**WELWYN HATFIELD BOROUGH COUNCIL
EXECUTIVE DIRECTOR - PLANNING, PUBLIC PROTECTION AND GOVERNANCE**

DELEGATED APPLICATION

Application No: 6/2021/1788/FULL
Location: Campus West The Campus Welwyn Garden City AL8 6BX
Proposal: Installation of an air source heat pump.
Officer: Mr Raymond Lee

Recommendation: Granted

Drw No. P4252-PESP-AZ-RF-DR-ME-58-9153

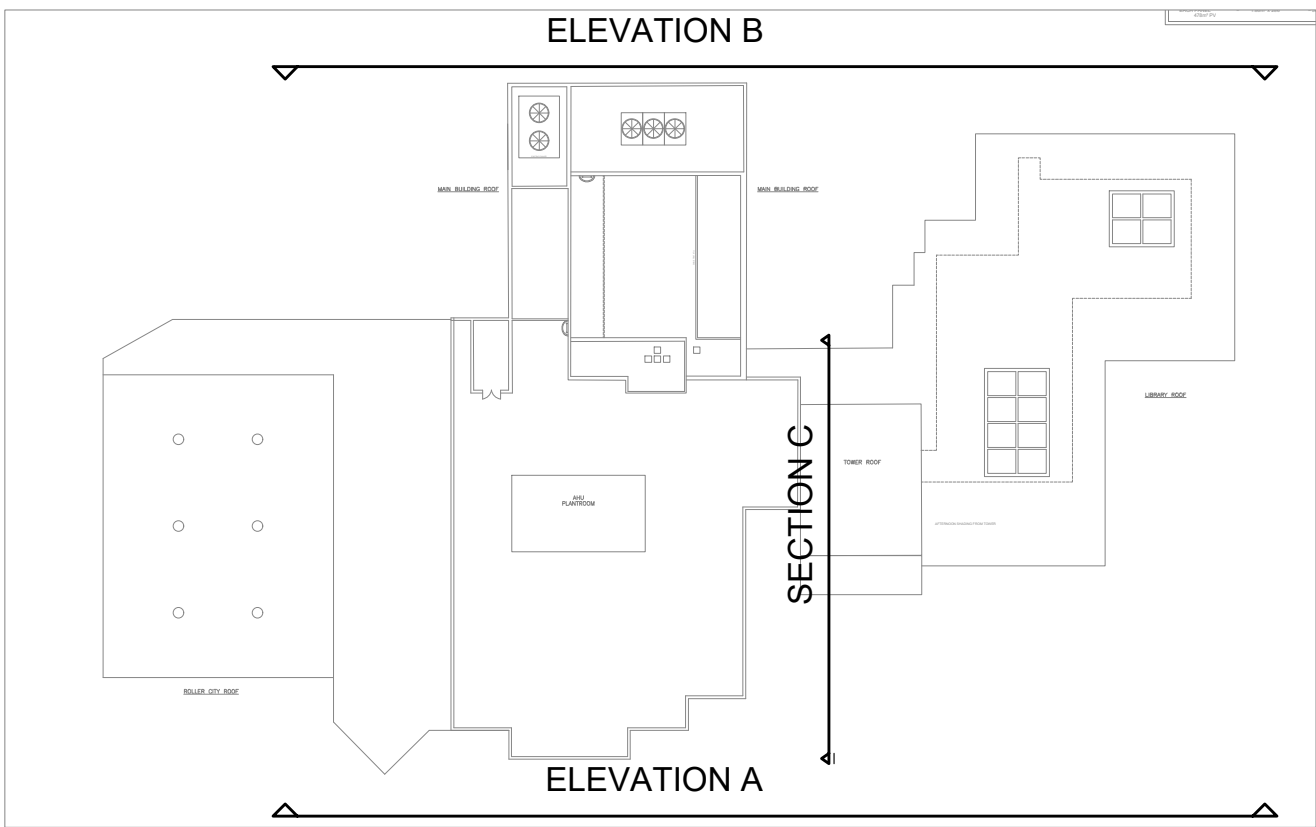
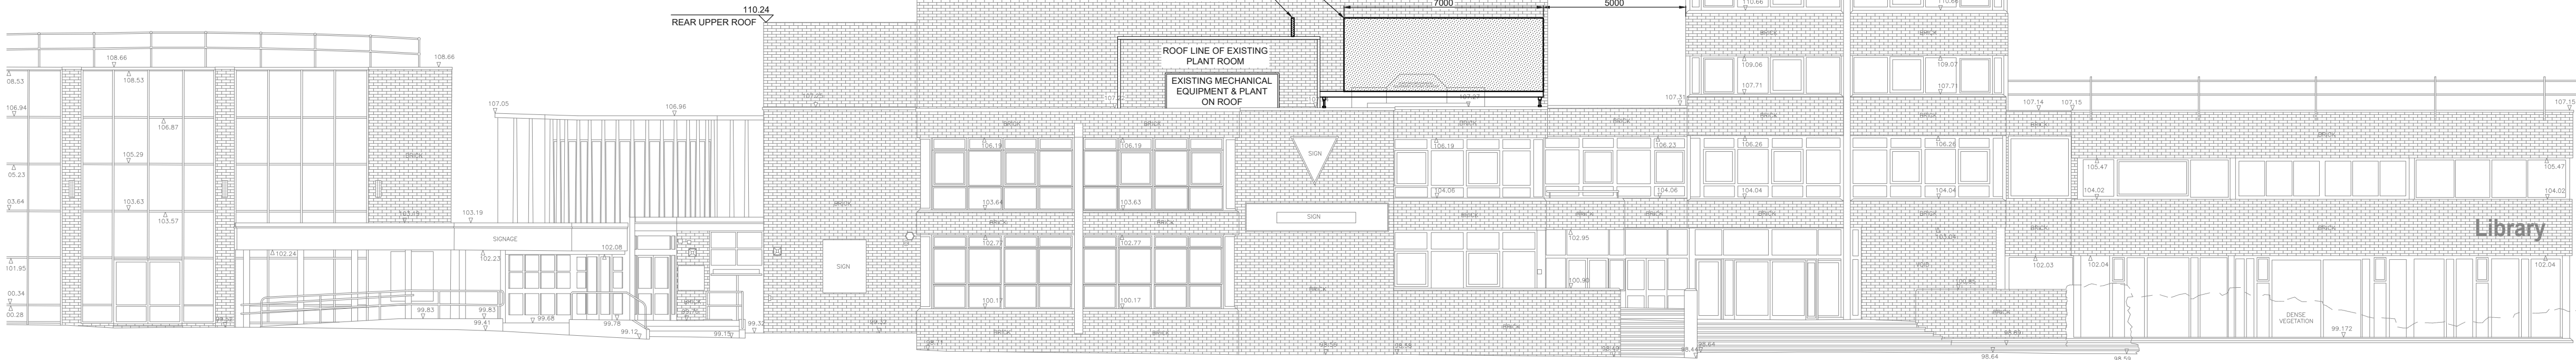
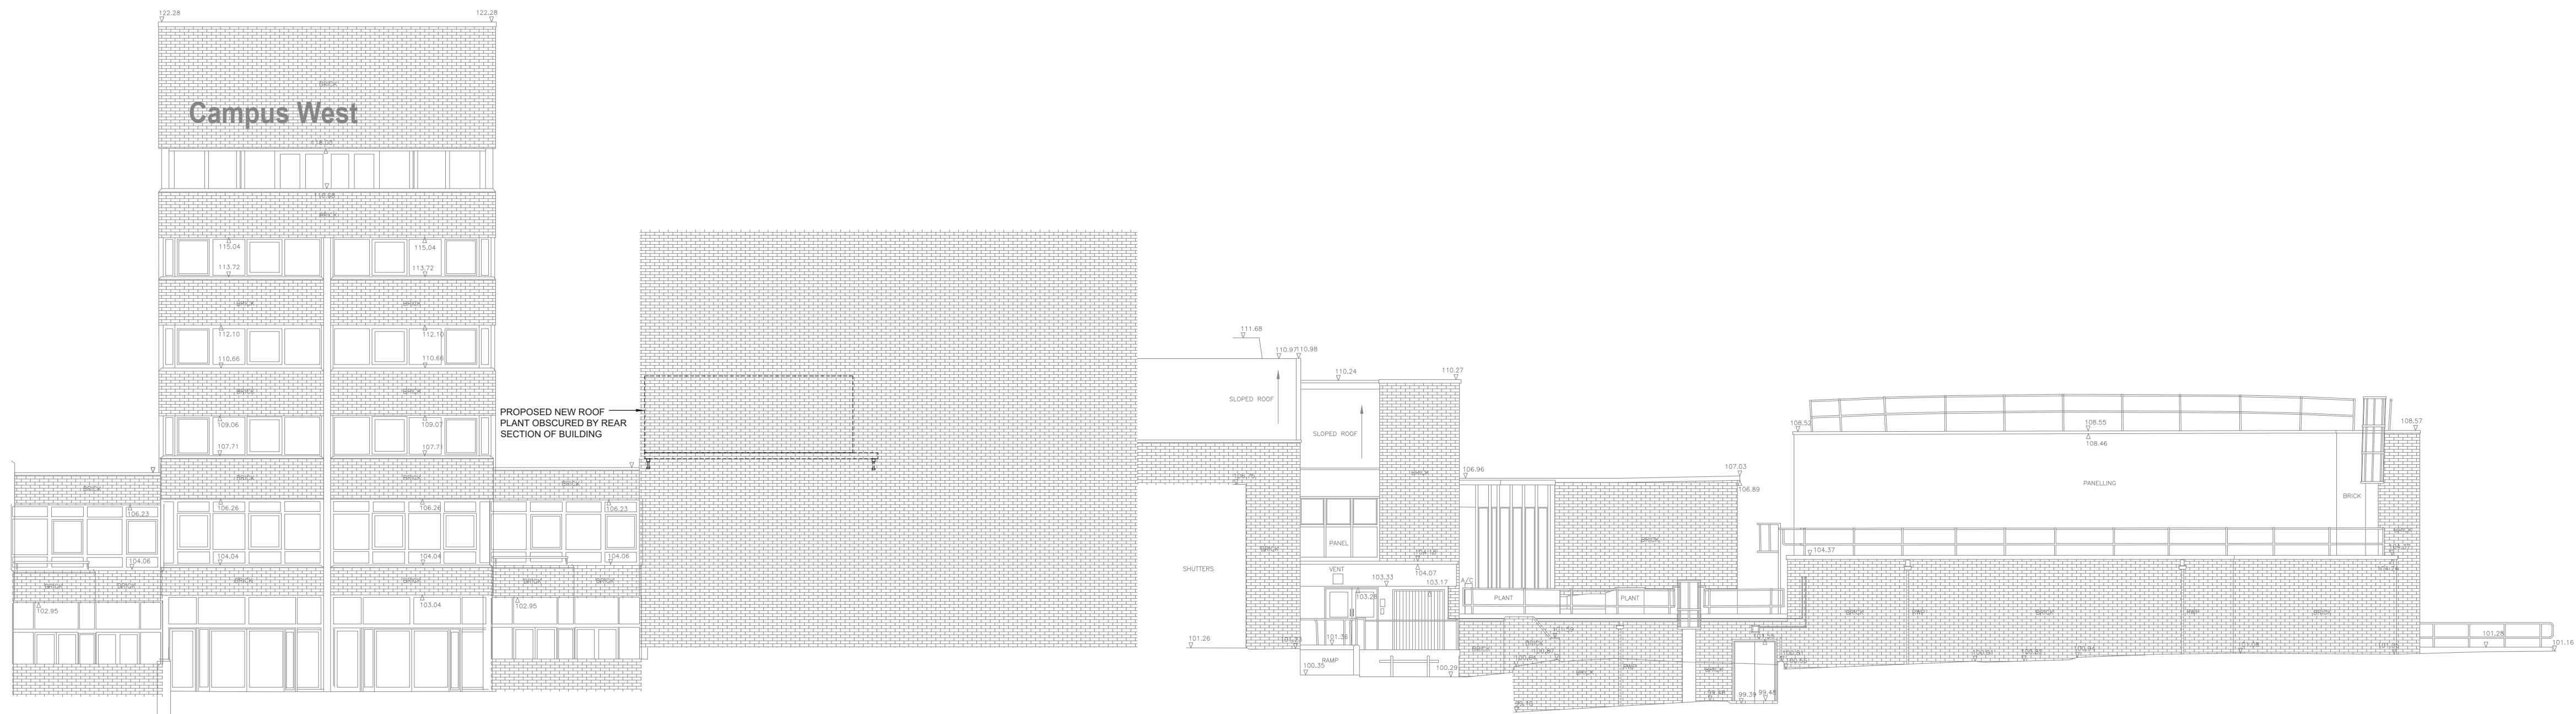
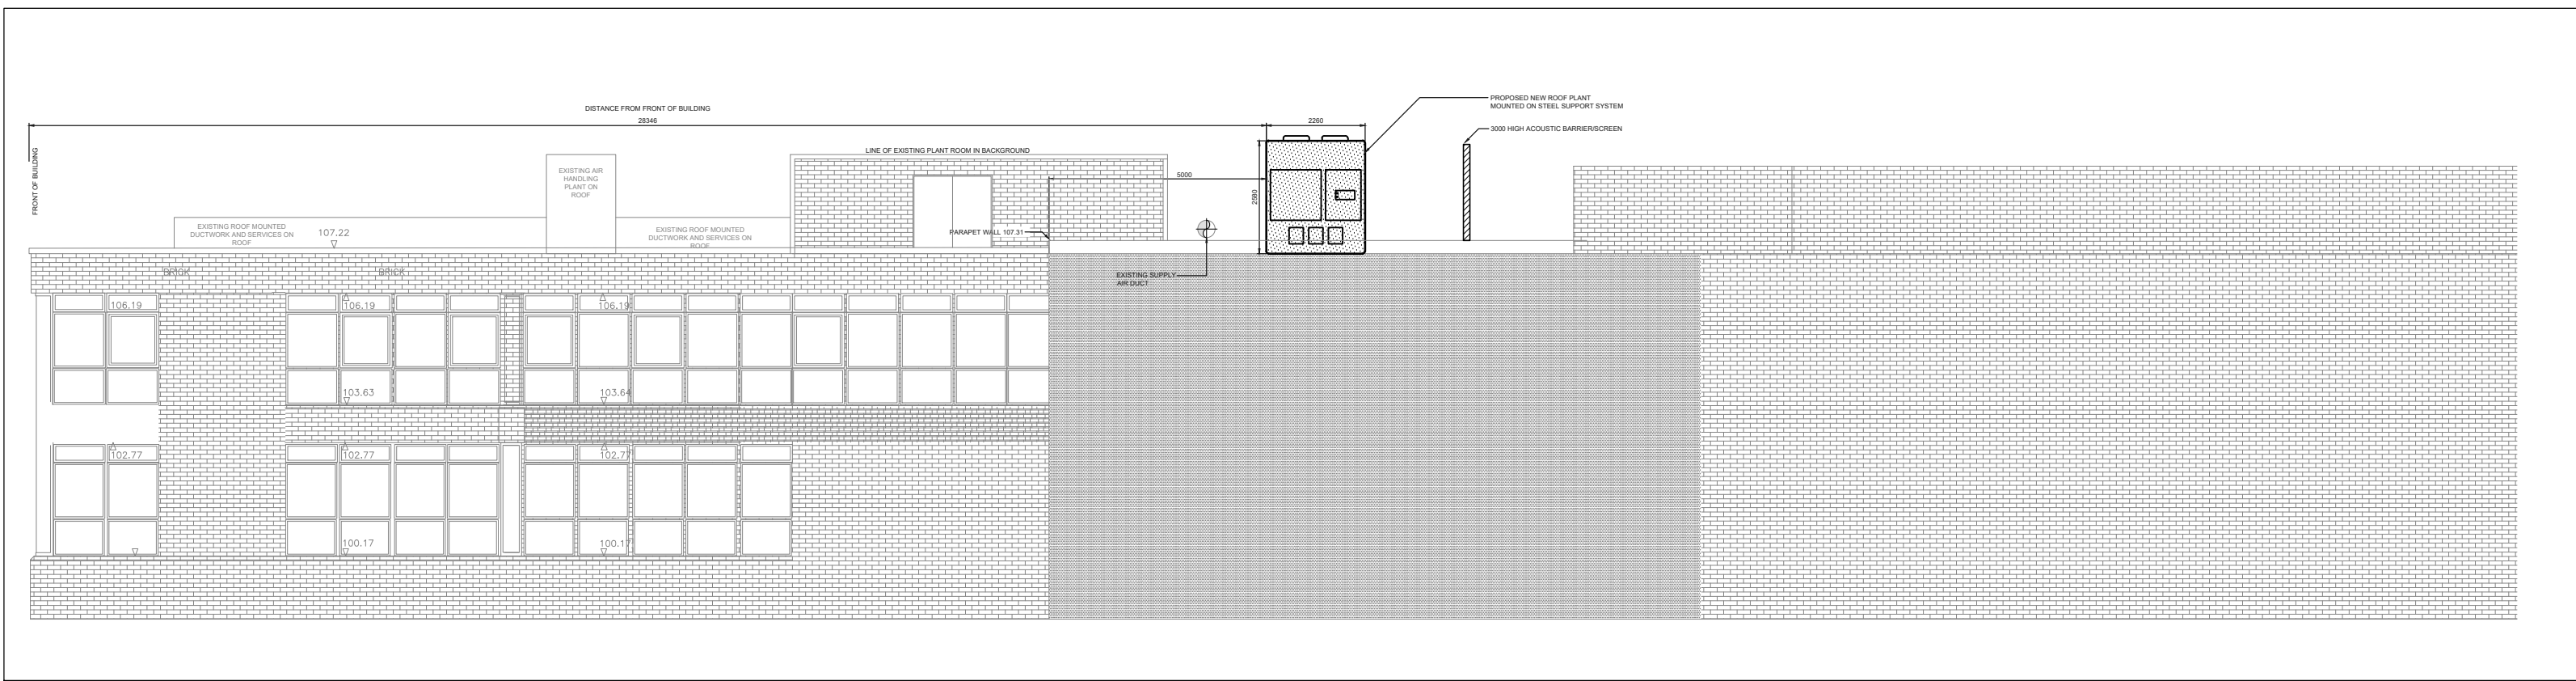
In this case, the proposed roof plant structure is a large structure at approximately 2.58 metres in height and 7 metres in length. The elevation and section drawings illustrate the position of the plant structure on the roof, and section C-C demonstrates that it is set relatively far back on the roof from the elevation (A) fronting The Campus. Long views of Campus West from locations across The Campus are possible, but many are filtered by trees when they are in leaf. The proposed plant structure would be located alongside existing plant on the roof which is perceivable in some views, but not prominent. Whilst the proposed plant structure is much larger than the existing structures on this part of the roof, it is not considered that it would appear as a prominent feature in views of Campus West from The Campus and would not detract from its overall appearance due to its set back position. No objections were therefore raised by the Conservation Officer.
